Recommendation Report for Planning Permission**REF NO:** EP/105/11/**LOCATION:** 46 Old Worthing Road
East Preston**PROPOSAL:** Conversion of house to 2 no. self contained 2 bed cottages**SITE AND SURROUNDINGS**

Drawing:
Plans and elevations as proposed

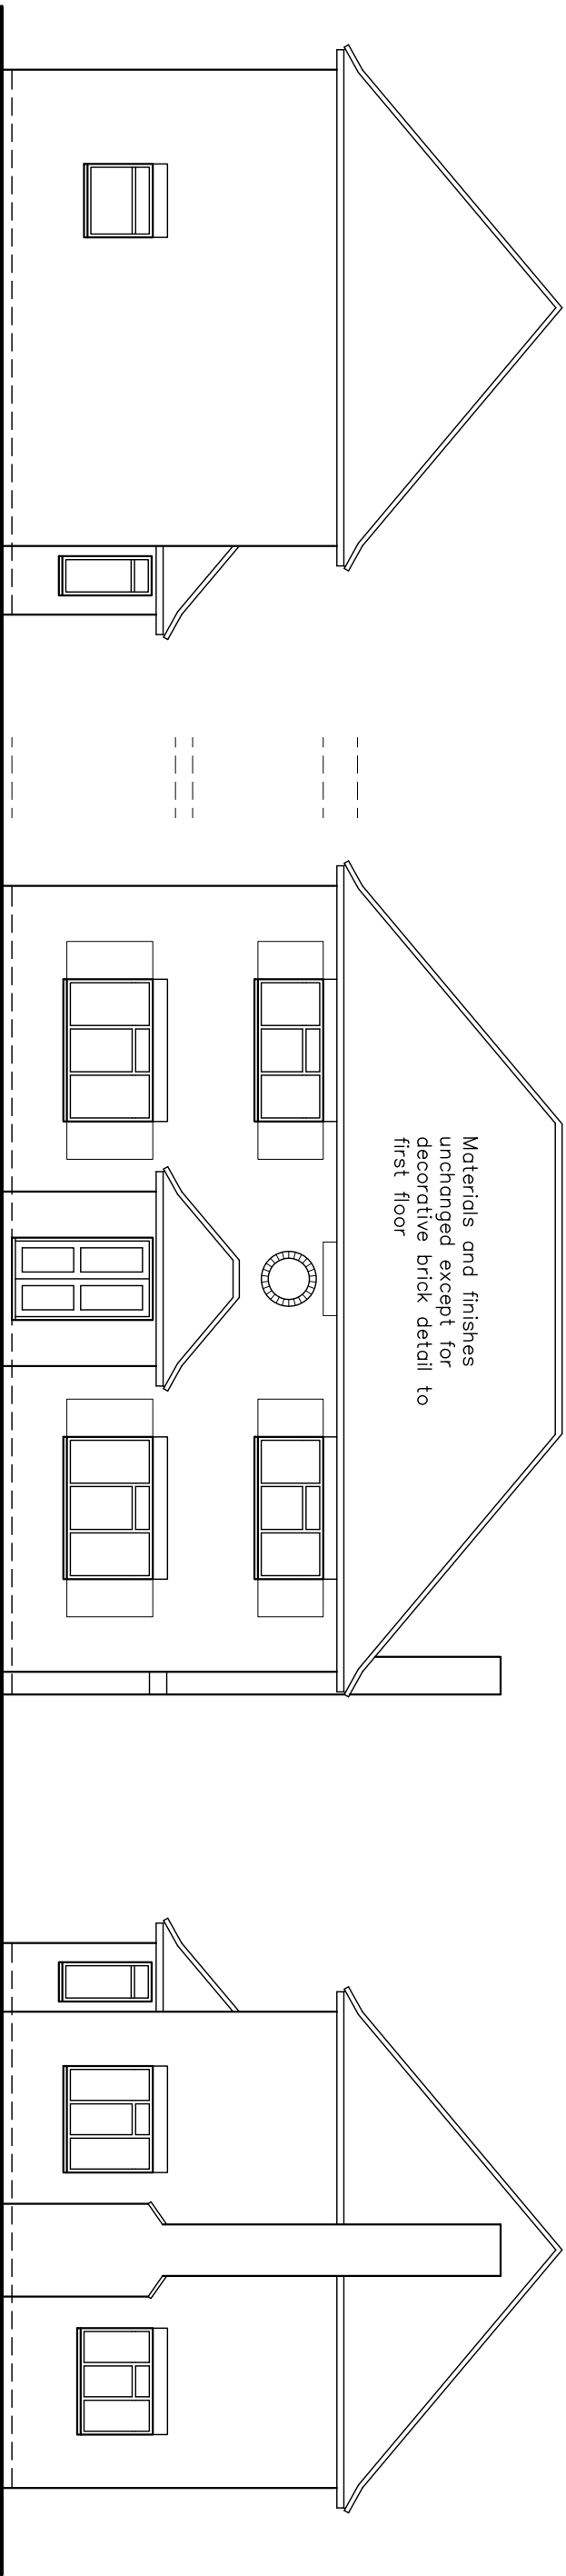
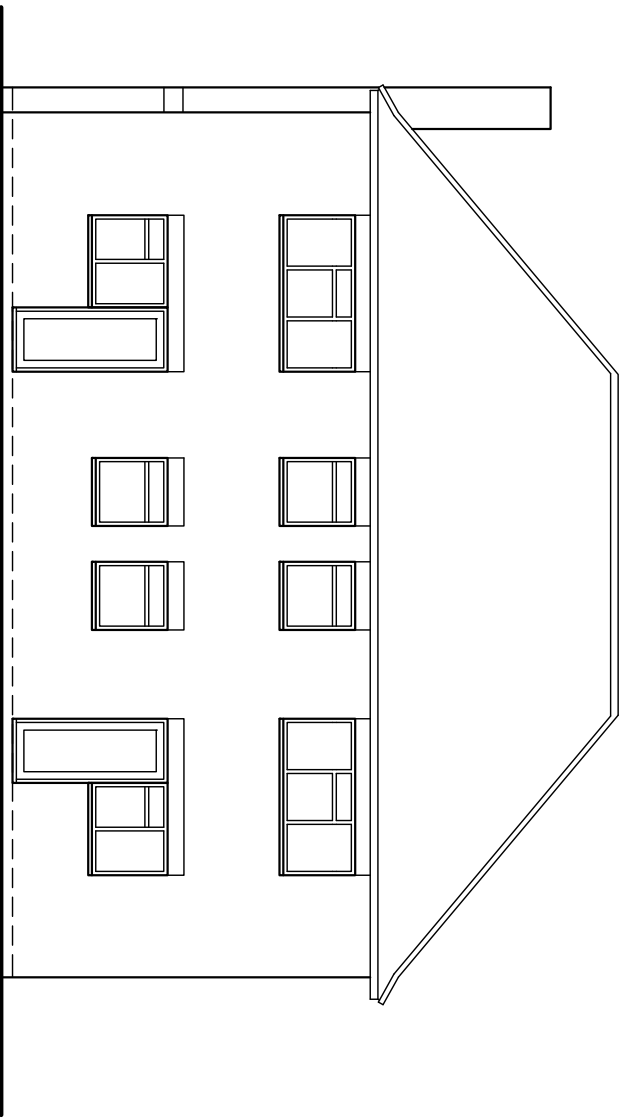
The proposed impact upon the visual amenity of the locality is considered to be minimal, notable changes are the removal of 1st floor windows to the front and west side elevations. These changes would not materially affect the appearance of the dwelling and the removal of the side windows would also reduce the level of overlooking of neighbouring sites which is currently available.

Project: Proposed conversion from 4 bed house to 2 2bed cottages; 46 Old Worthing Road, East Preston BN16 1DY	
Drawing: Block plan	
For: Mr. Lee	
Drawn: PKS	Date: August 2011
Scales: 1:500	No: 1160/01/06
To scale when printed on A3

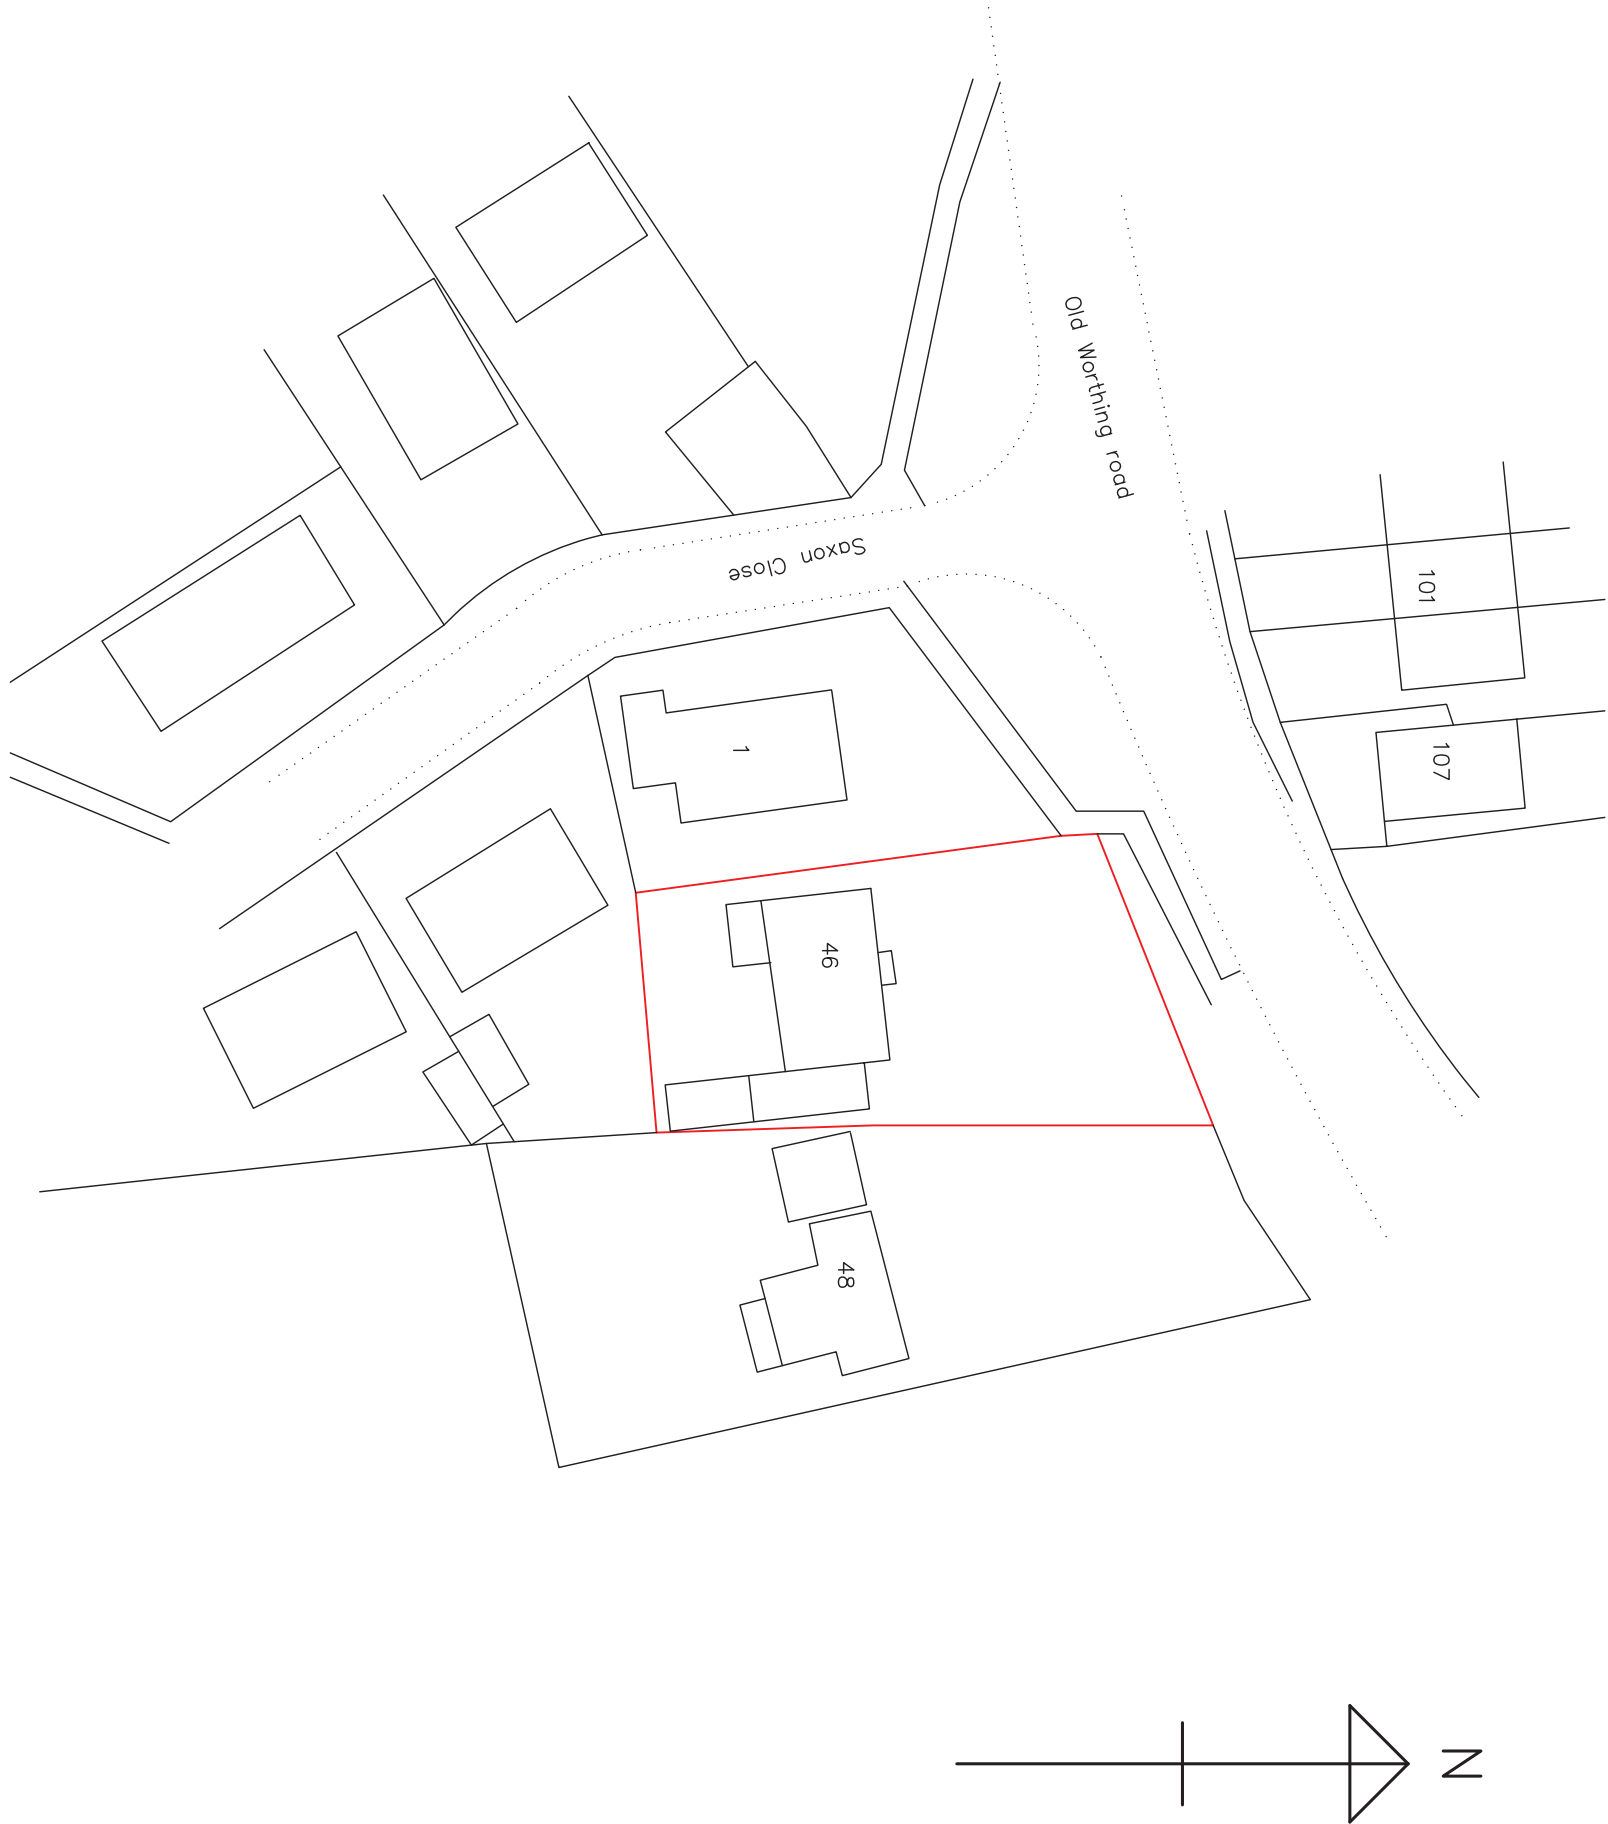
Comments noted. However given that the plans provide detail identifying 4No. proposed parking spaces and sufficient area is maintained on-site for the turning of vehicles, a condition is not considered to be required.

The site provides 4No. off-street parking spaces and an area within the site for the turning of vehicles clear of the highway. This does not provides an acceptable level of parking, in accordance with West Sussex County Councils parking standards which requires 5No. parking spaces to be provided on site. However it is considered to be sufficient for the proposed development and the existing drive way is sufficient for on-site turning as well as visitor parking.
